Your Ref: OWPC13428
Our Ref: EP/42/17/PL 10-03-2017
Please ask for:
Mrs A Gardner

Alterations to existing public conveniences including provision of disabled facilities & ramped access to toilet.

Public Conveniences Sea Road East Preston

Thank you for your internet representation made on 3rd April 2017 which has been recorded as '**no objection**' with the comments as follows:

Plans (1:50)

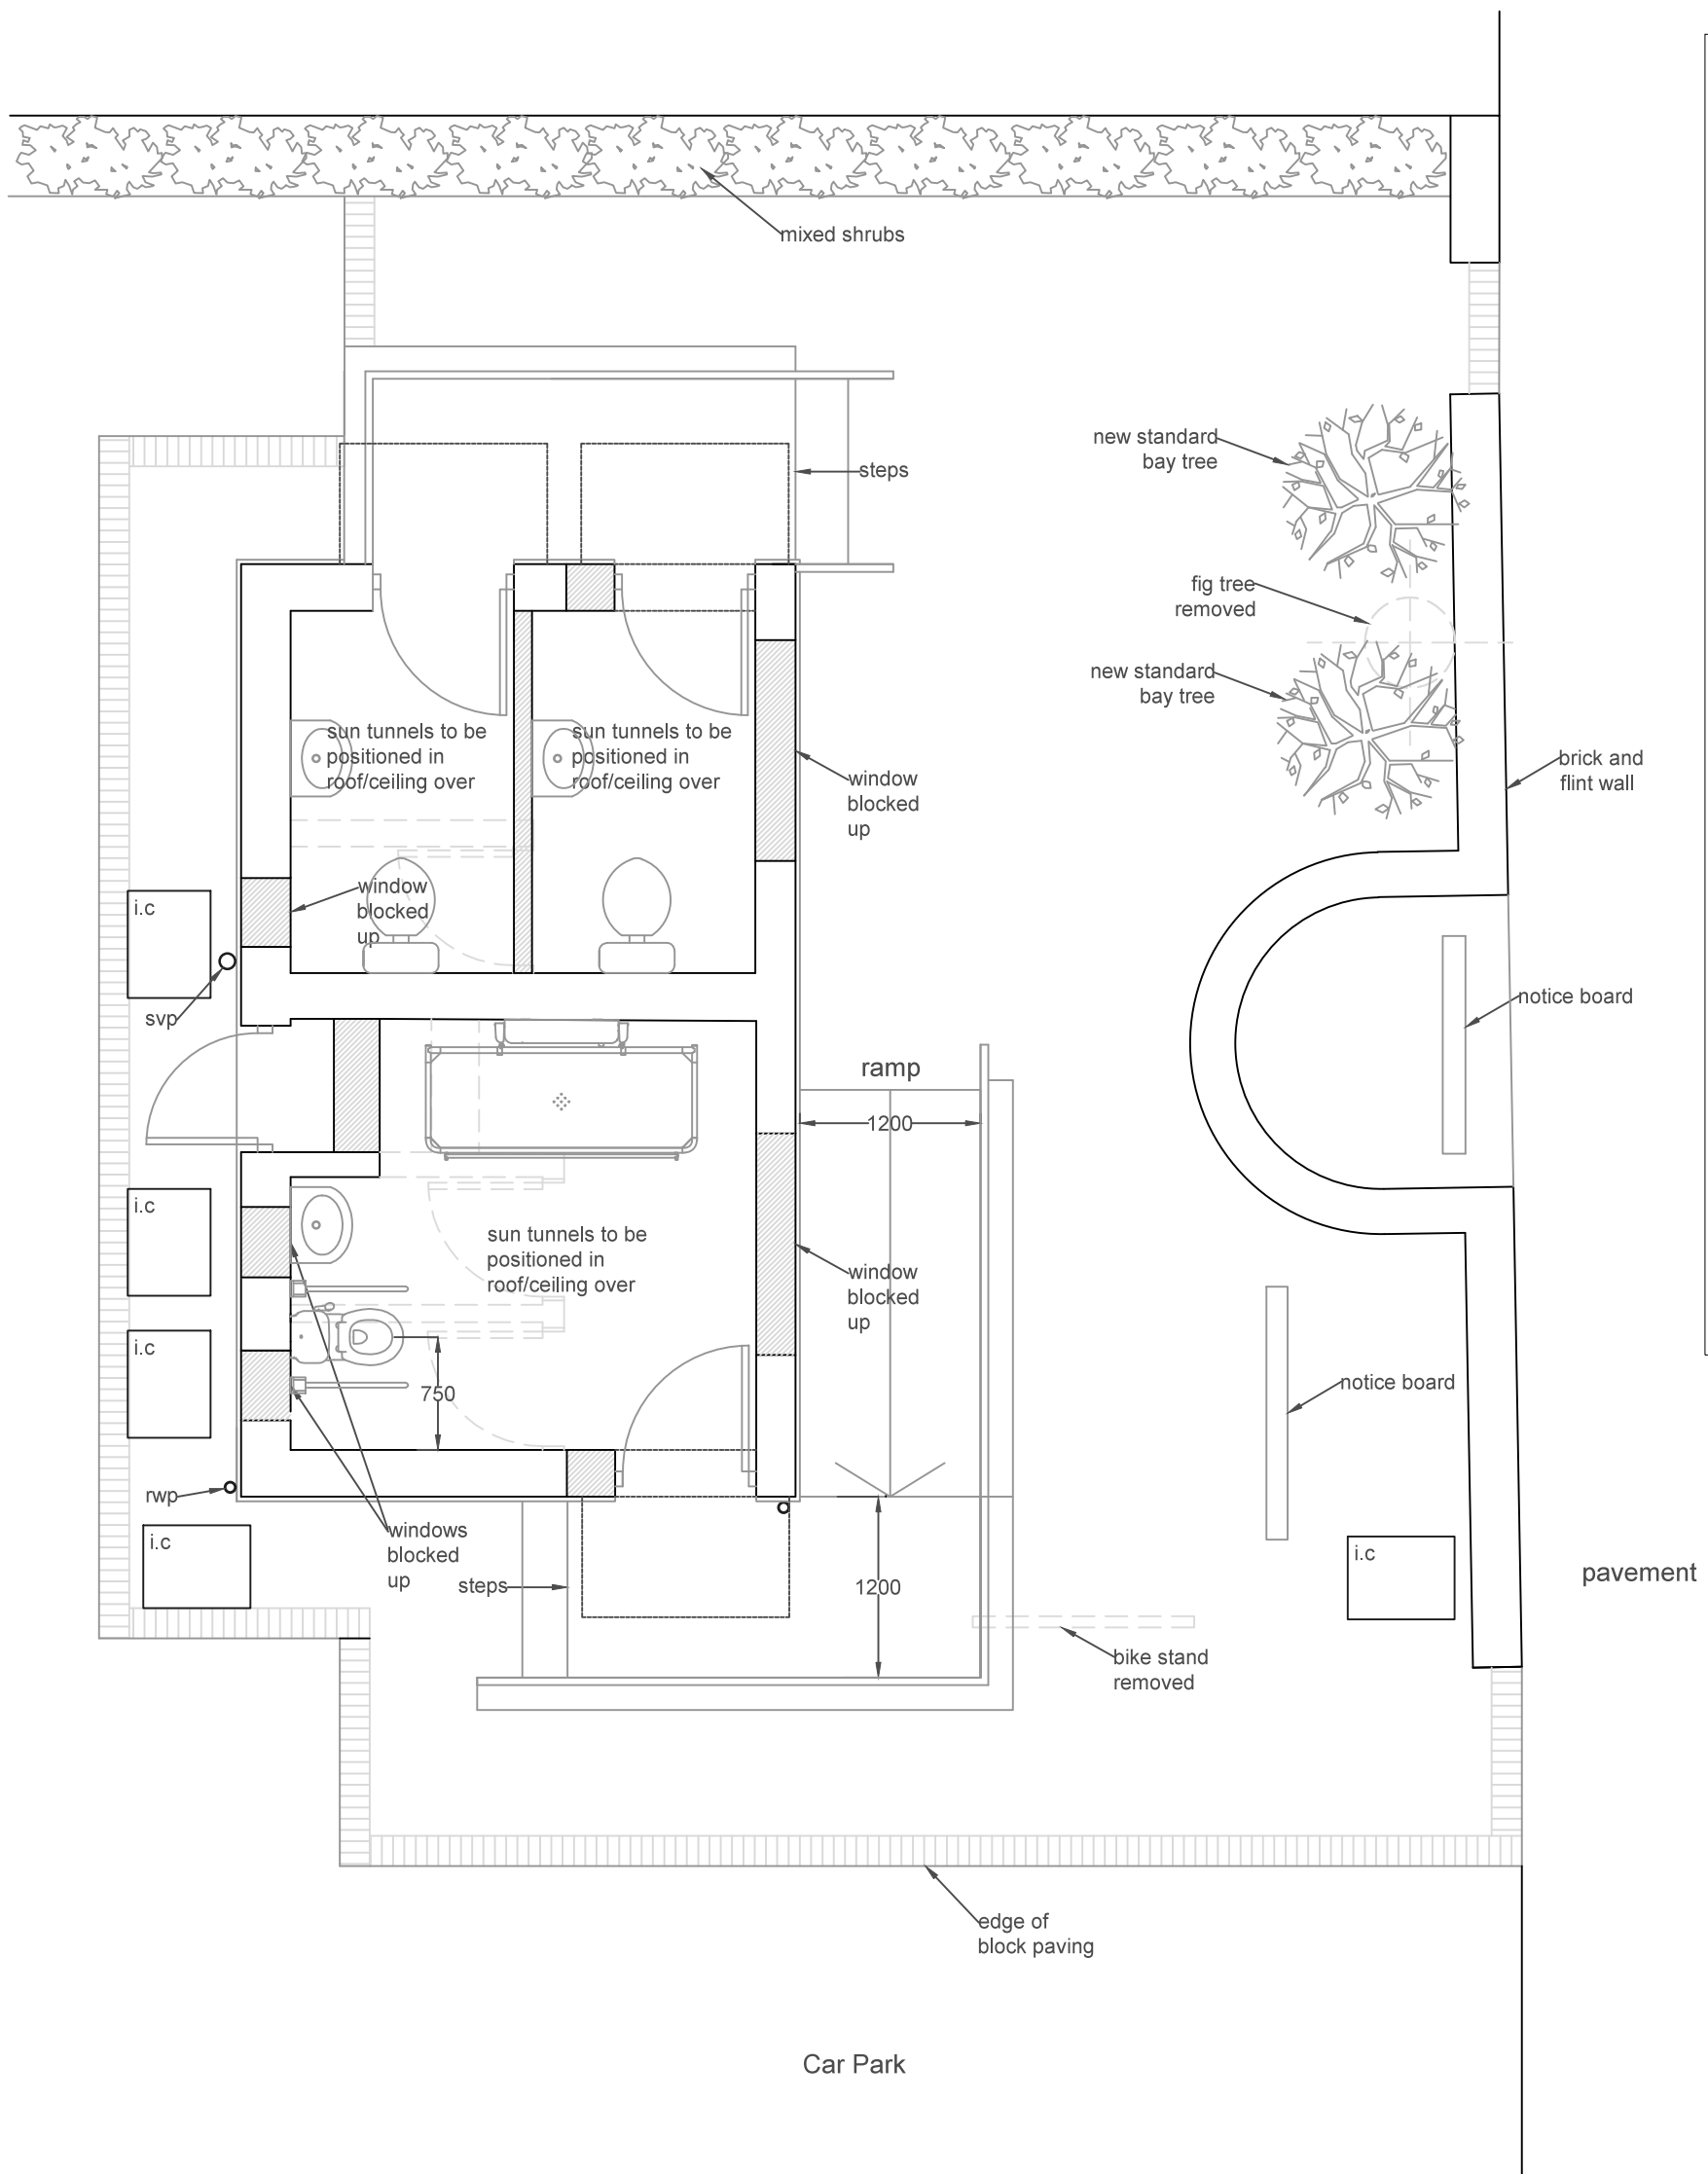
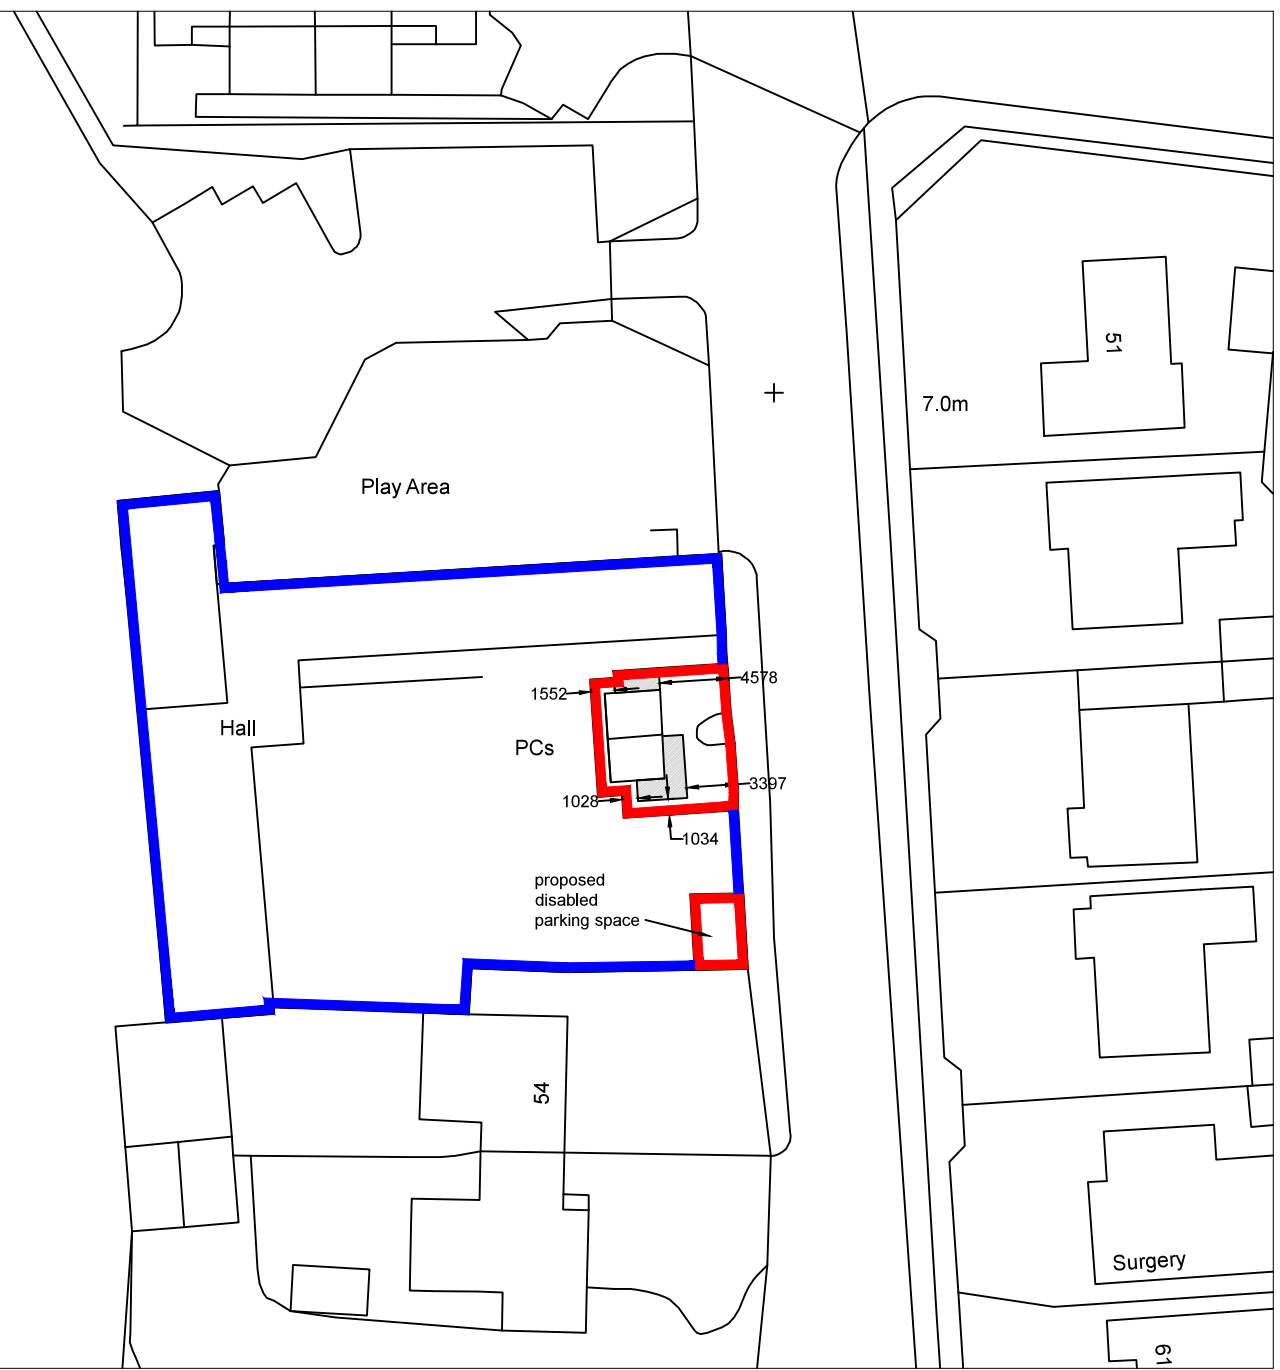
I notice that the existing rail for the secure "parking" of cycles has to be removed to make room for the ramp (and access to the ramp) but I don't see any indication of a replacement for this cycle storage area on the site. I hope this facility will not be lost.
